21, Downview Road, Felpham, Nr.Bognor Regis

Two storey extension

Application No. FP/112/12/CLP

No. 3/13/04 'X'

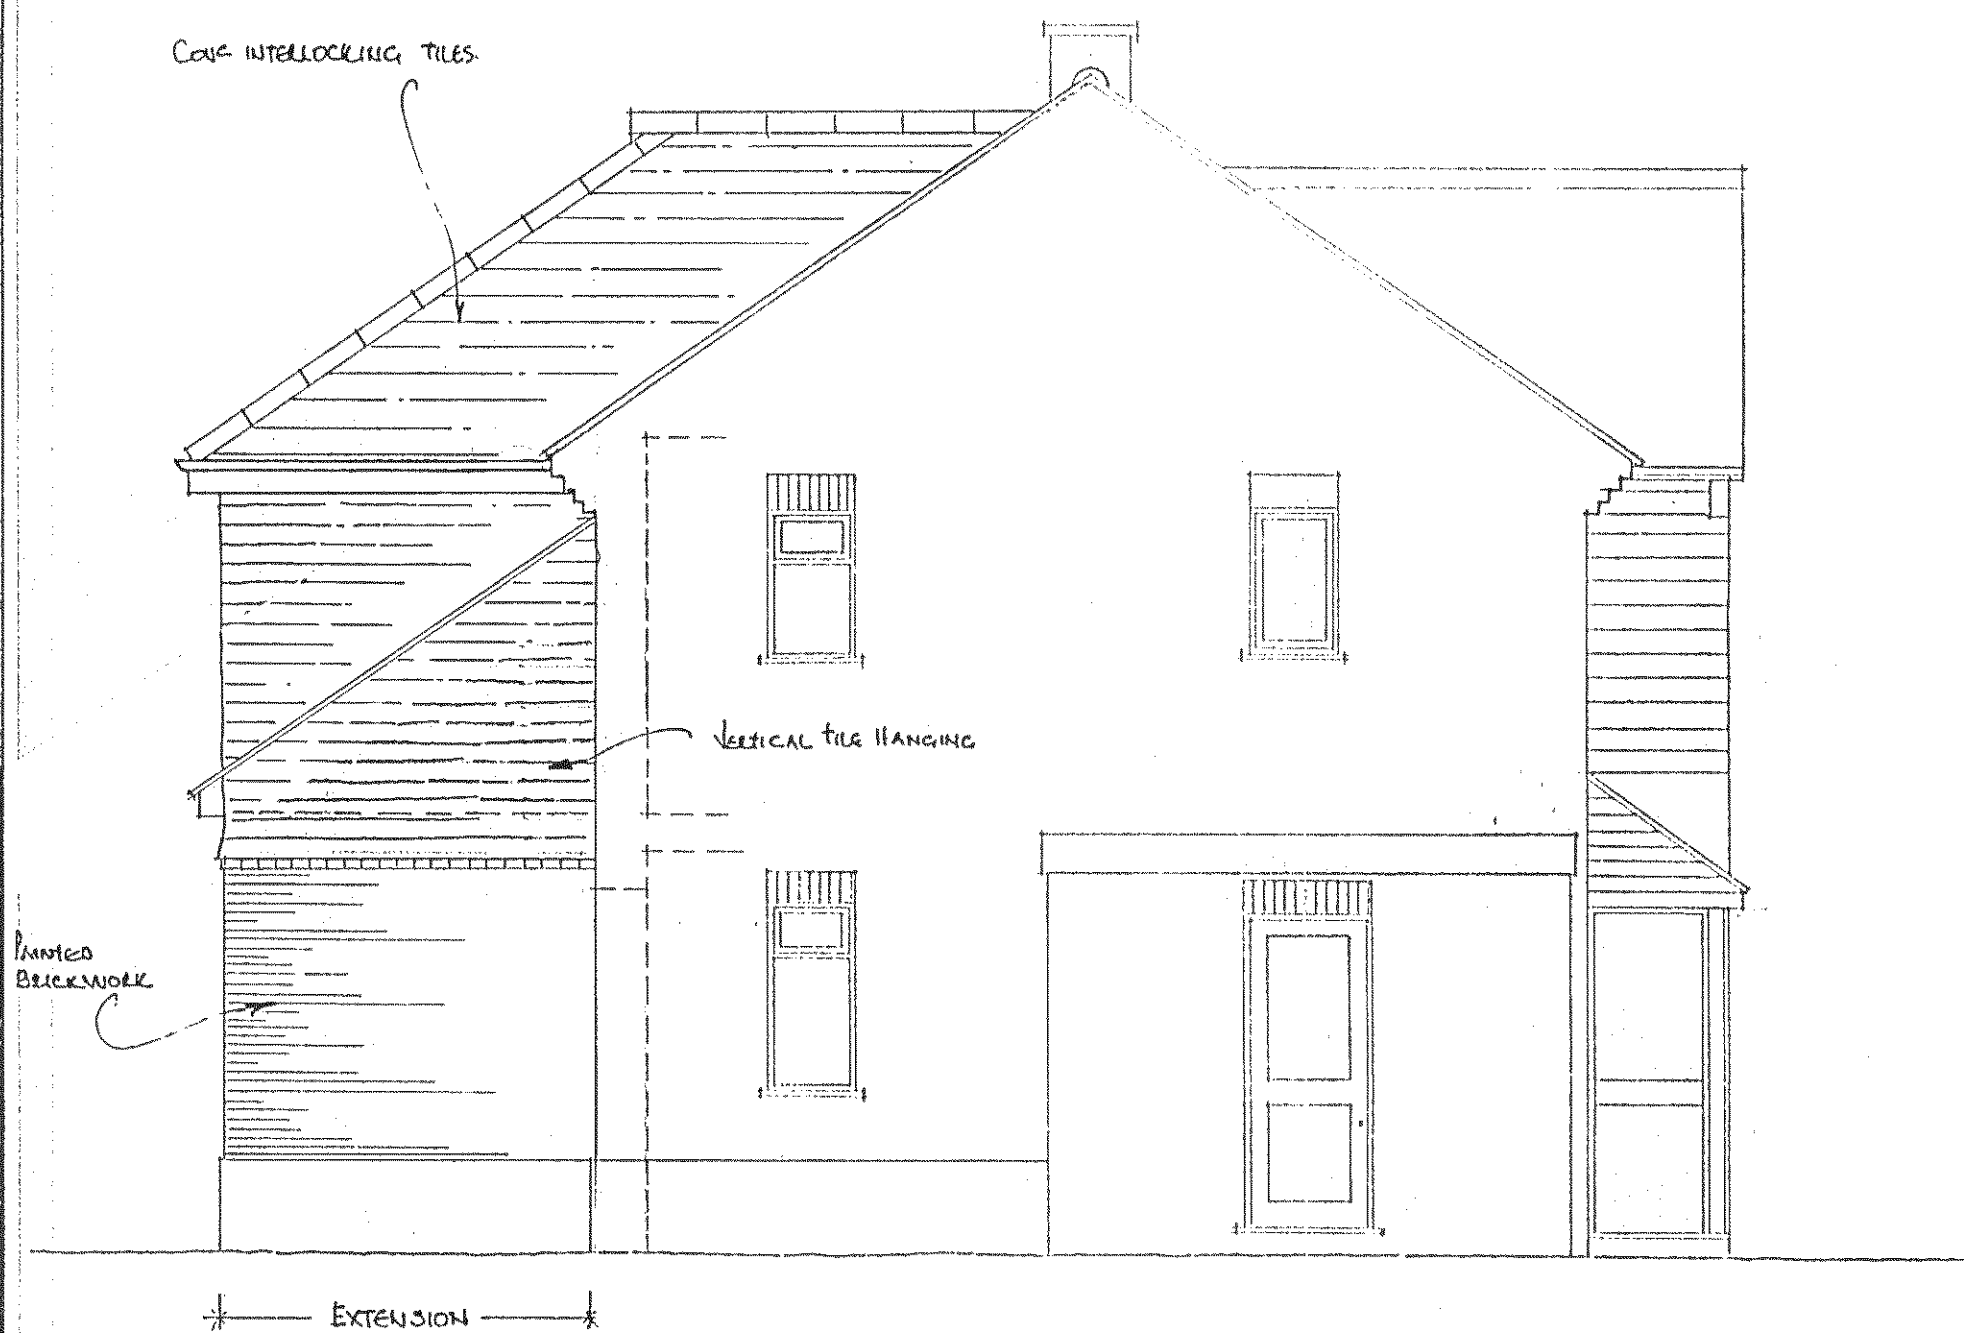
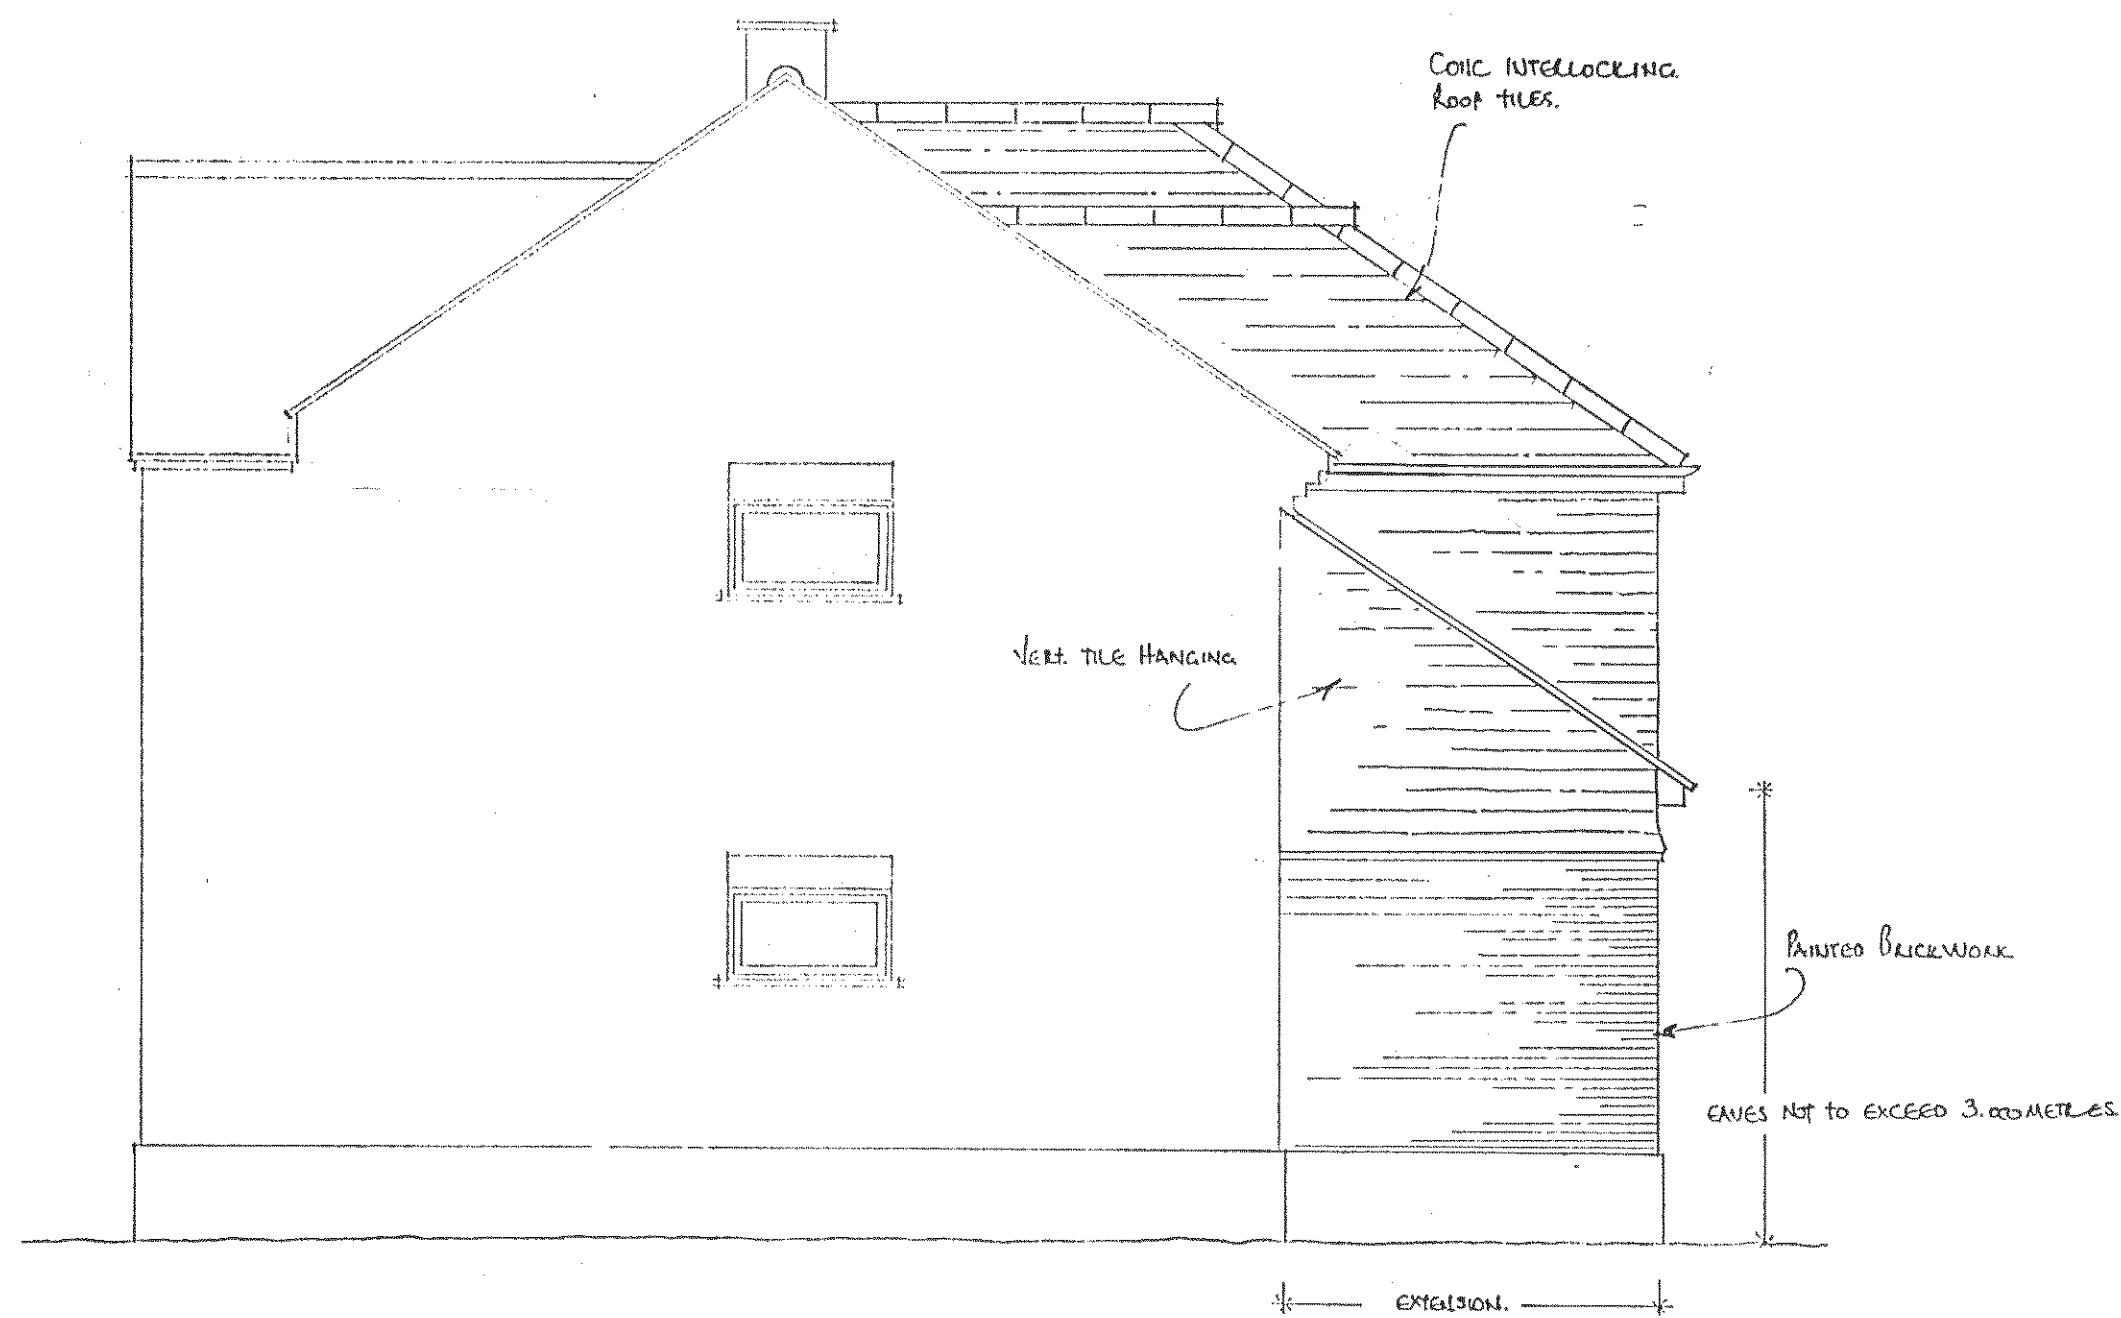
Further to my telephone conversation & my subsequent meeting with your Mrs J.Chapman I attach two copies of my revised drawing No.3/13/04 'A' as discussed which shows the proposed eaves of the extension amended to a maximum height of 3.000 metres to comply with the guidelines set out to allow the proposed extension to be deemed 'Permitted Development'
